File No: NTH09/01728/08

Your Ref: SSD7198

**Response to Submissions – Moonee Beach Residential Subdivision, Moonee Parklands Trust (SSD7198) – Lot 1DP1097743**

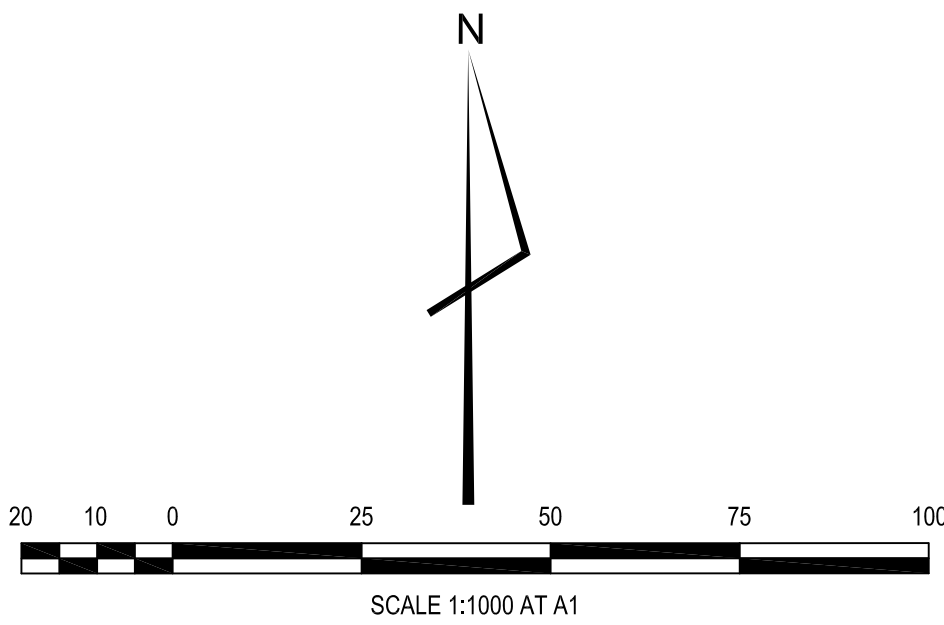
road shown as '*approved collector road – Road 1*' on Plan 1277-DR1 Issue F is not proposed for removal.

1. It is understood that relevant proponents have entered (or will enter) into agreements for the construction of the Northern Collector Road and that all access to the future development will be via Moonee Beach Road and the Pacific Highway interchange. It is further understood that prior to the release of any Subdivision Certificate for any new residential lot, interim or final, all existing property access to the Pacific Highway will be legally and physically closed and redirected via the Northern Collector Road to Moonee Beach Road. This Road is shown as '*approved collector road – Road 1*' on Plan 1277-DR1 Issue F.
